Dear Miss Greenwood,
Your ref: HA/2018/120208/01-L01
LA Planning ref: FG/206/17/PL

Re: INSTALLATION OF SIX PUMP (12 FILLING POSITION) PETROL FILLING STATION, DRIVE-TO PAY KIOSK & ASSOCIATED WORKS INCLUDING JET WASH, AIR/WATER SERVICES & VACUUM EQUIPMENT.

LAND AT ASDA SUPERSTORE LITTLEHAMPTON ROAD FERRING BN12 6PN

## Geo-Environmental Appraisal

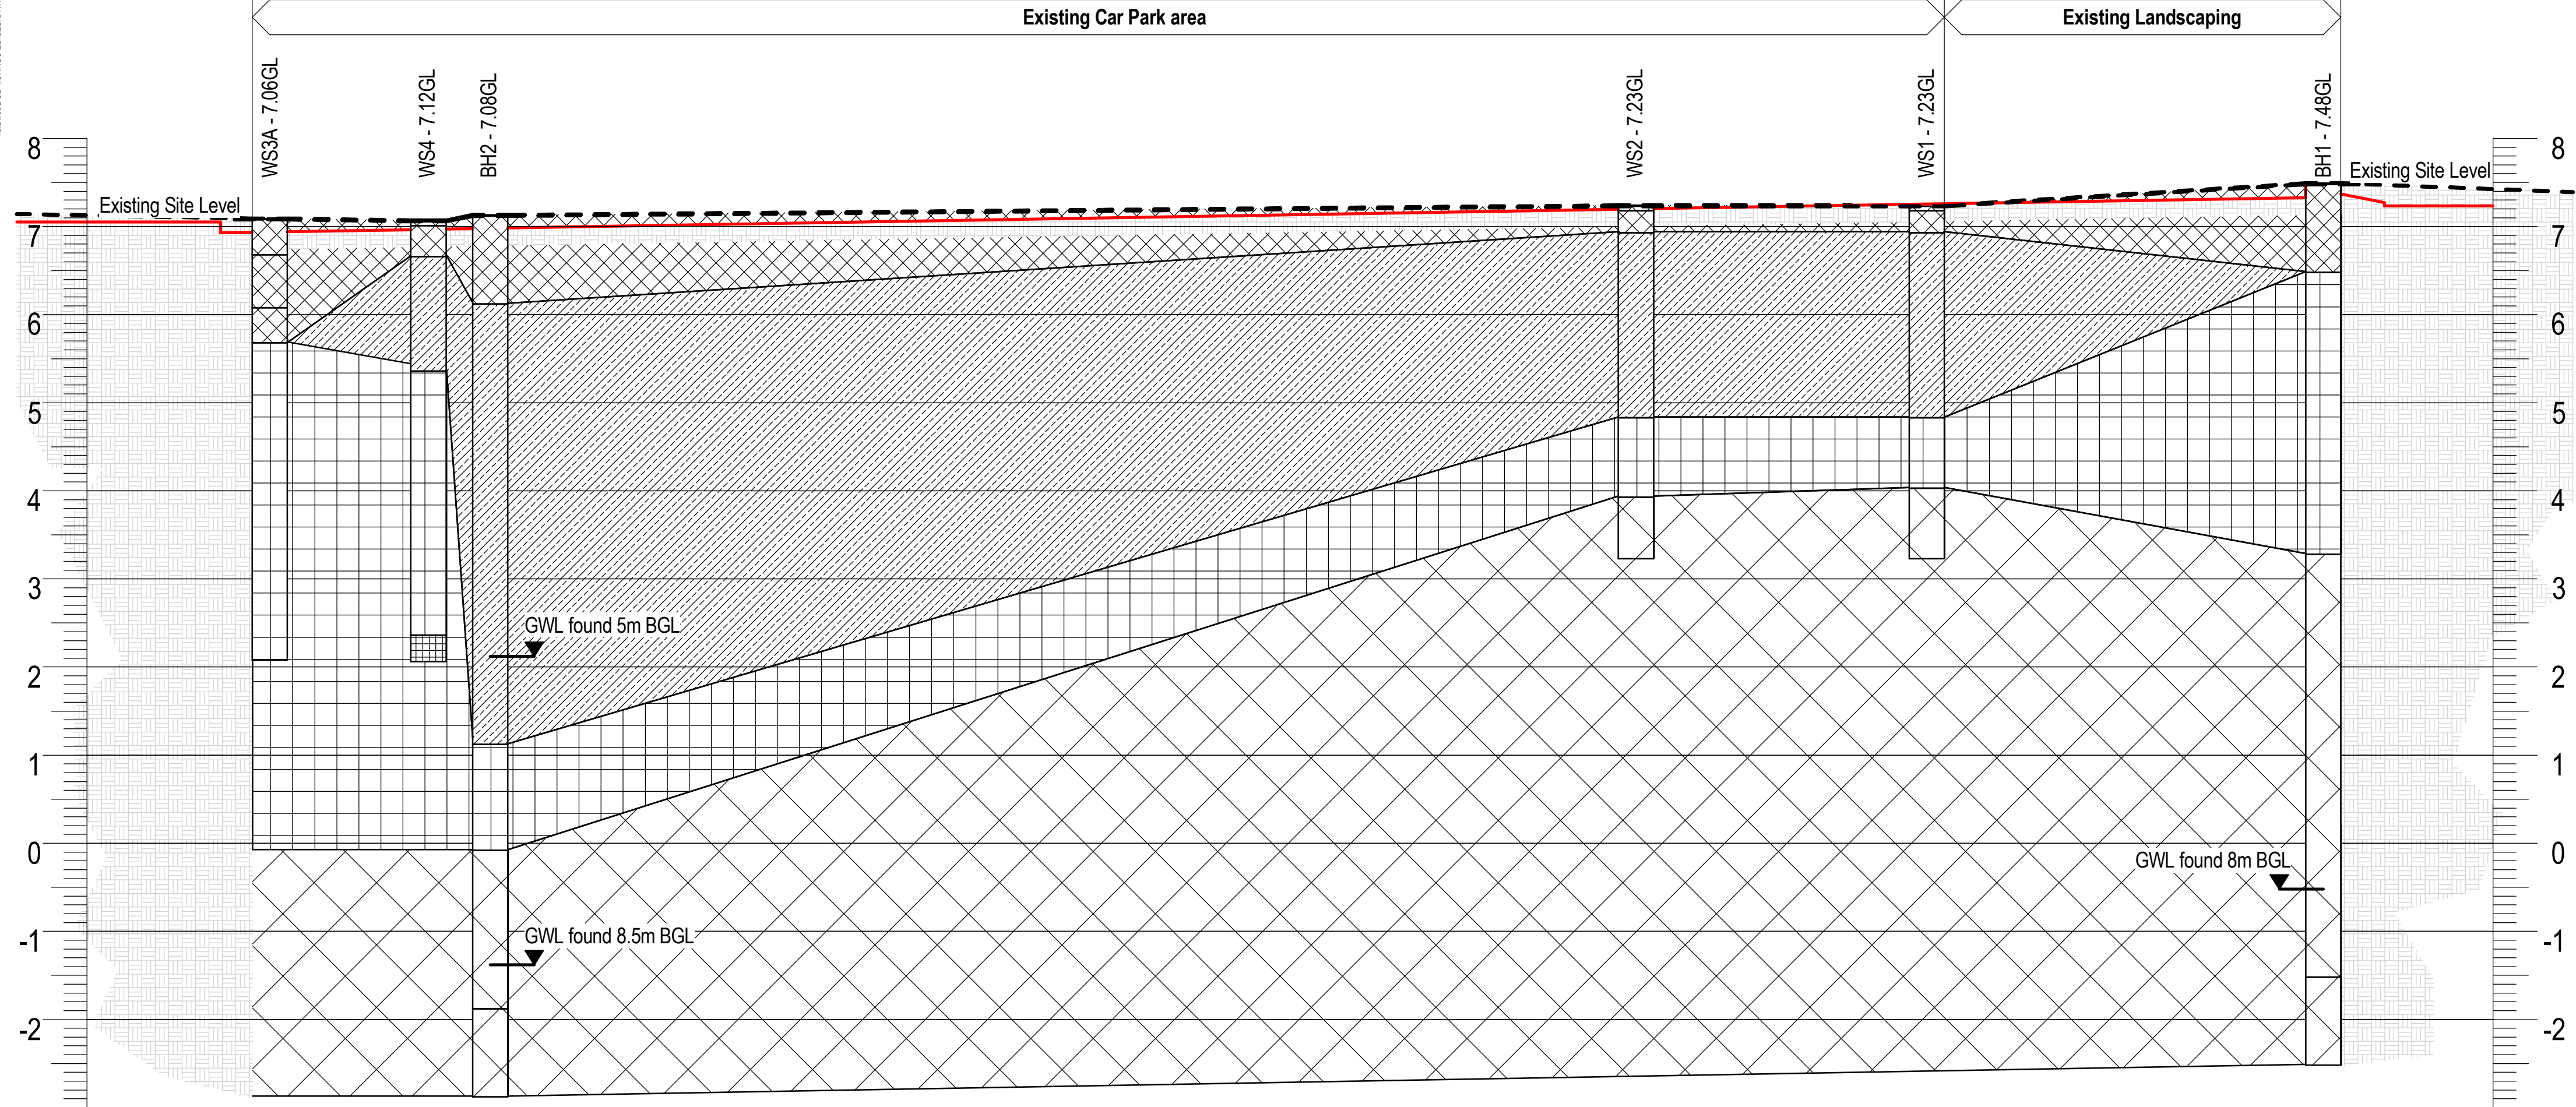
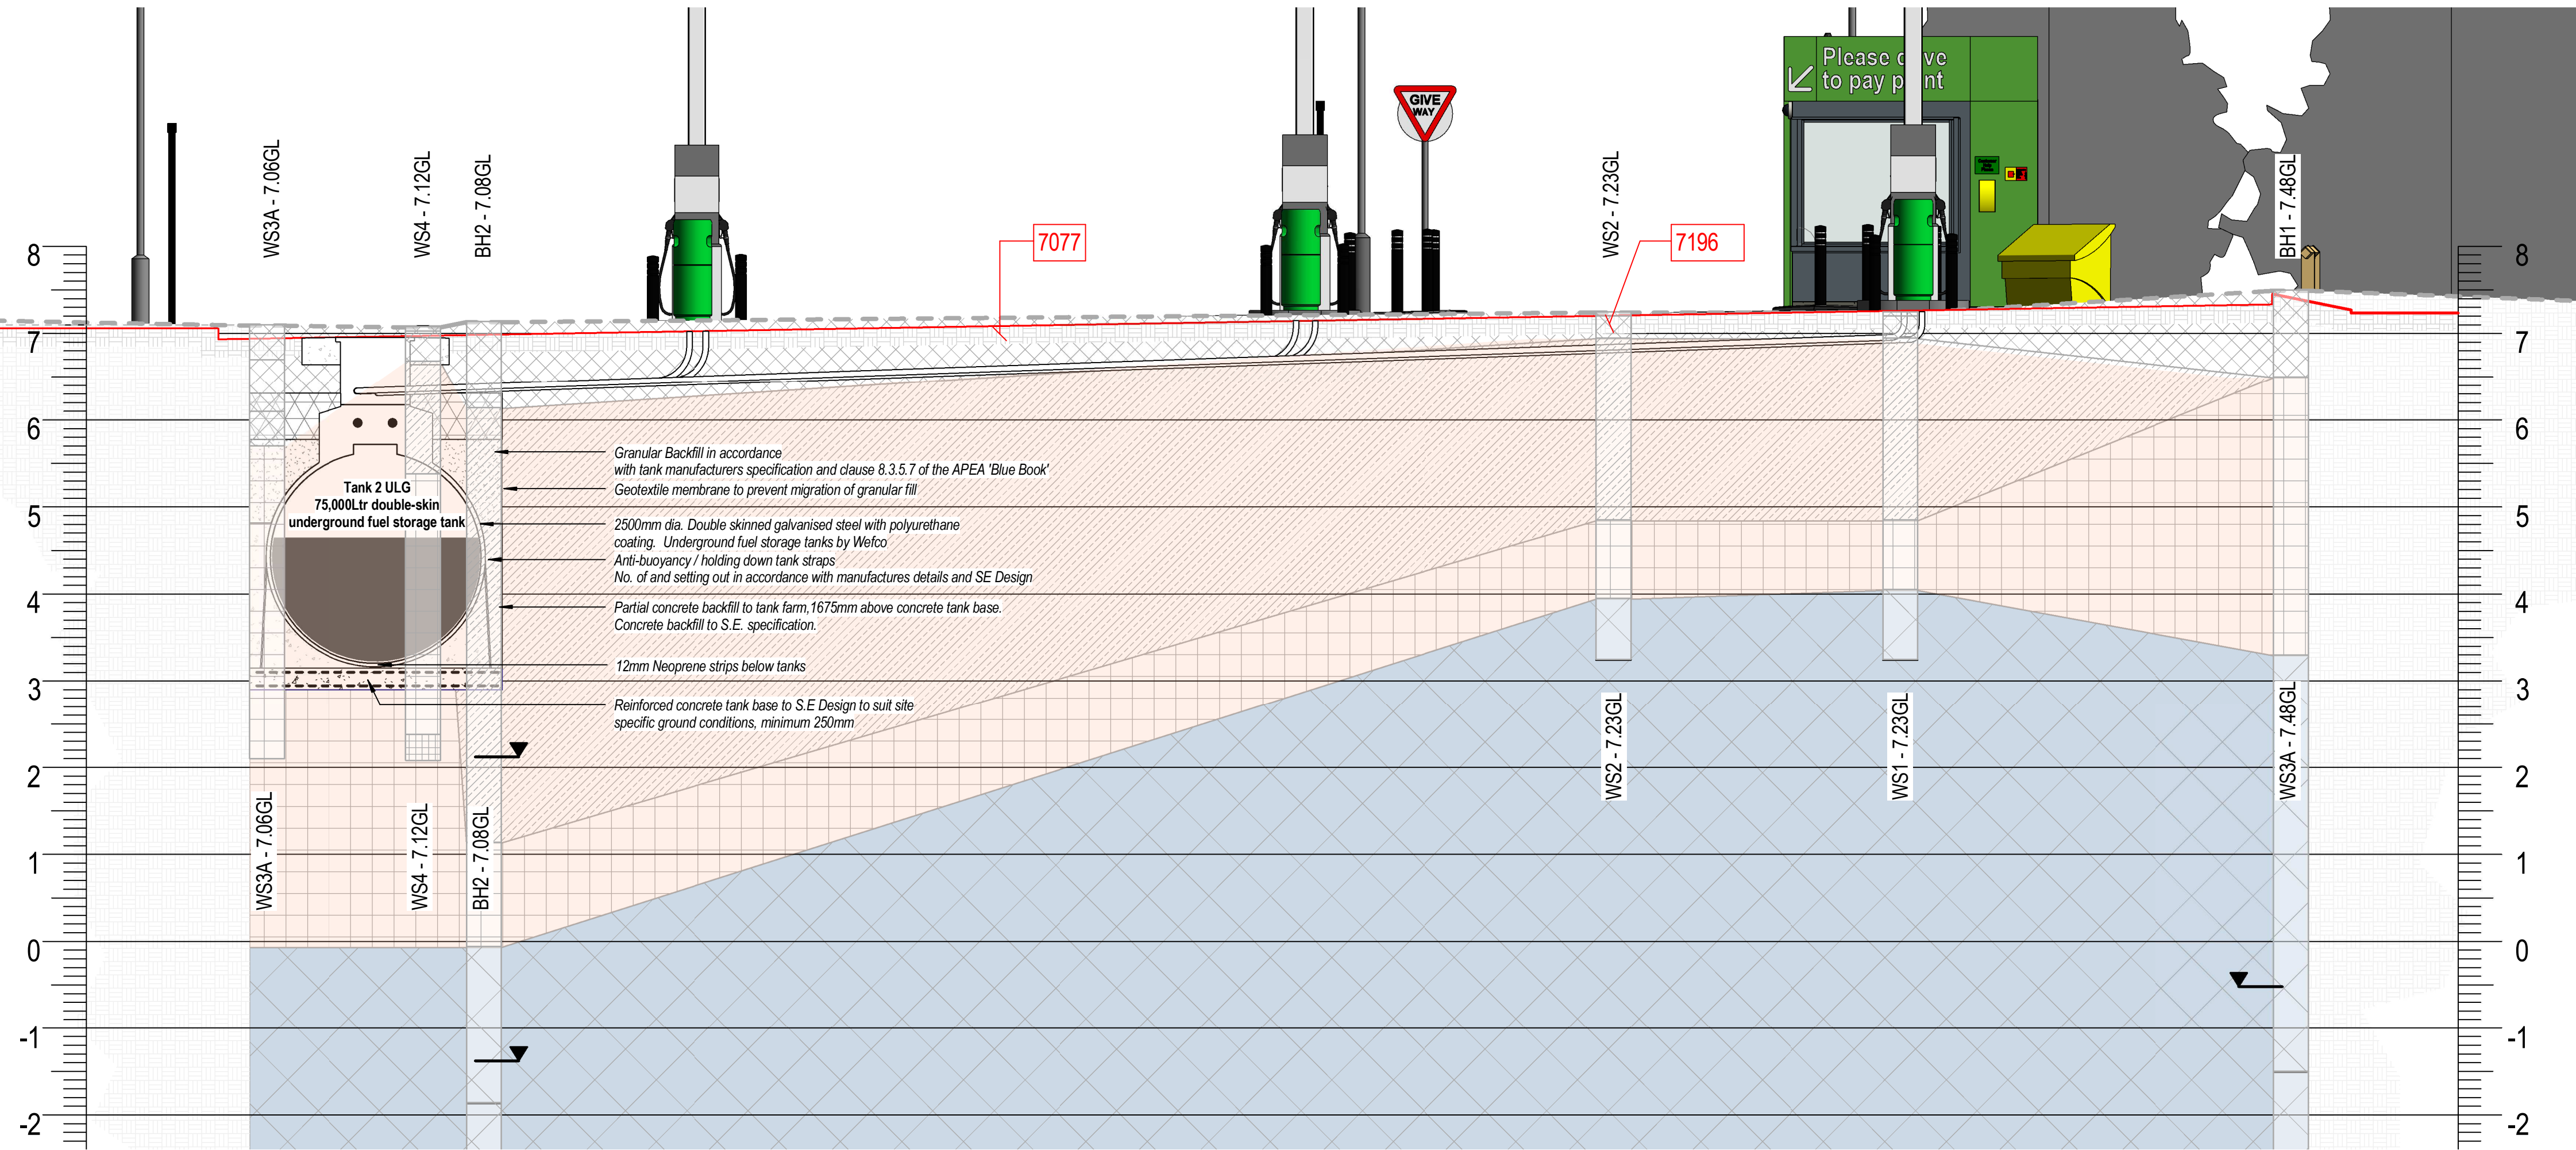
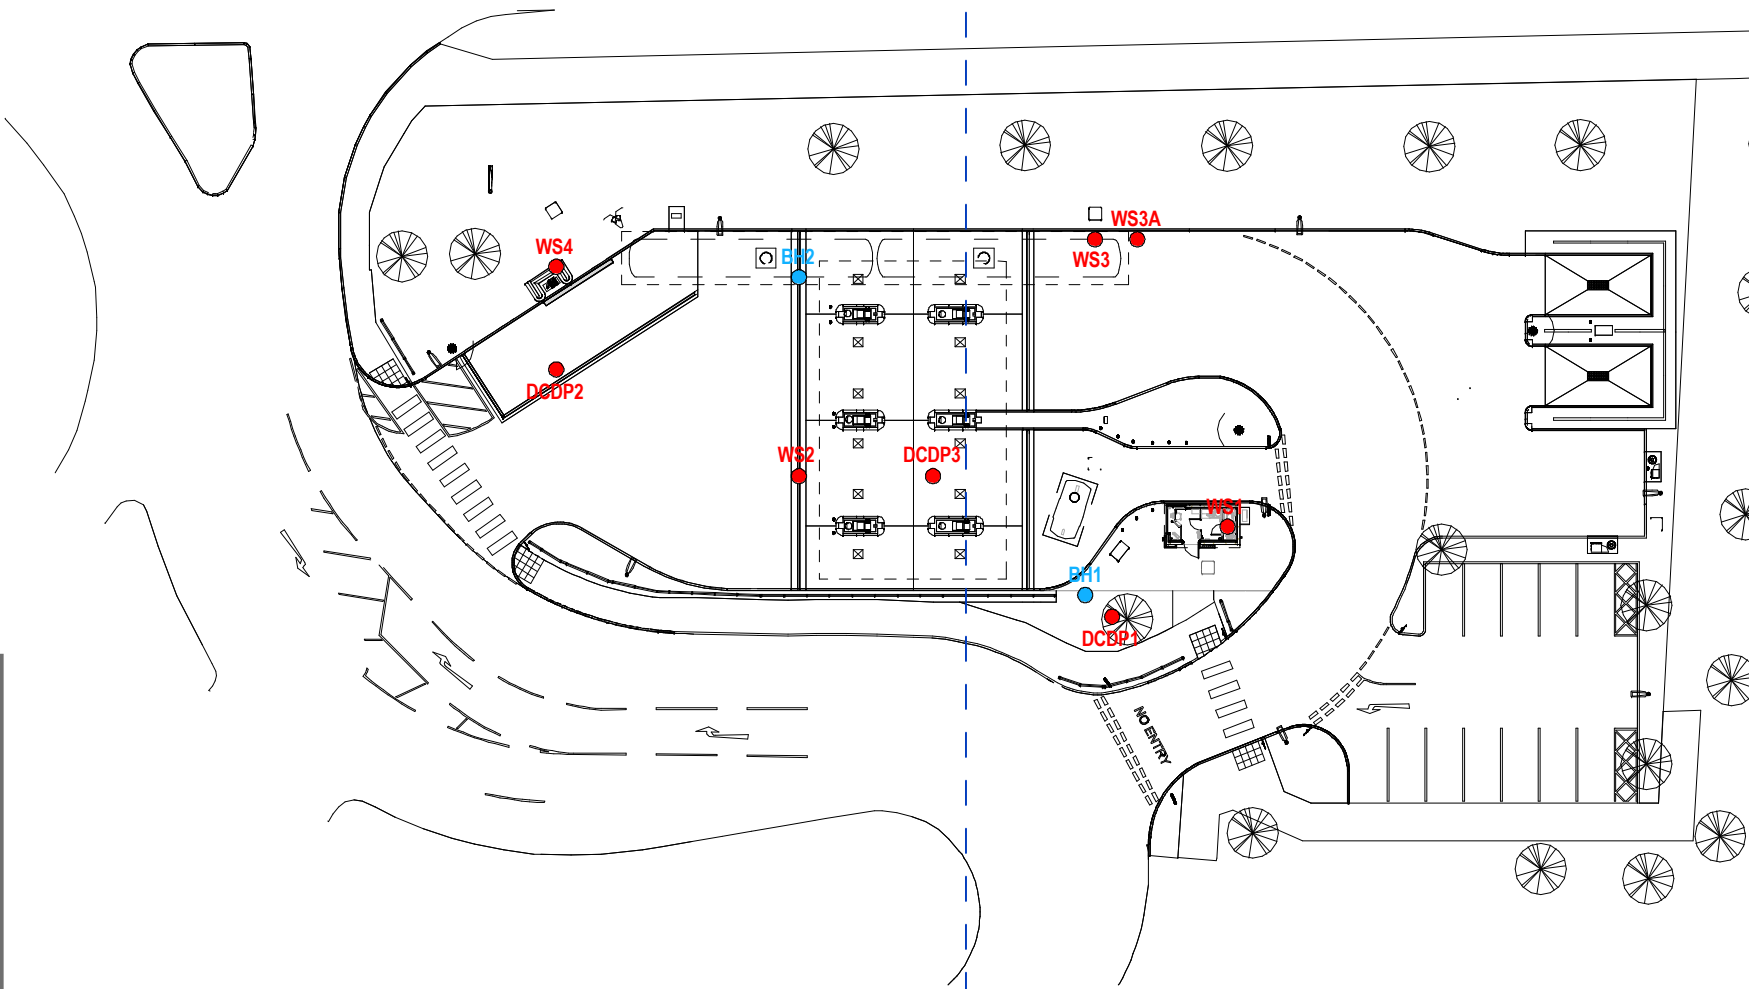
The proposed design of the underground tanks is inadequate. As the proposed tanks are to be developed below ground, groundwater levels may be such that they are sited below the groundwater table. We therefore recommend that the applicant addresses this environmental

risk, particularly with our Position Statement D2 and present a design that mitigates against any future pollution.

The tanks have been located in a linear format to the most Northerly part of the site (refer to '400_02 Geo-Environmental Appraisal Section') which ensures that the below ground tank installation does not a) breach the superficial clay barrier into the chalk layer below and b) is not situated below the groundwater level.
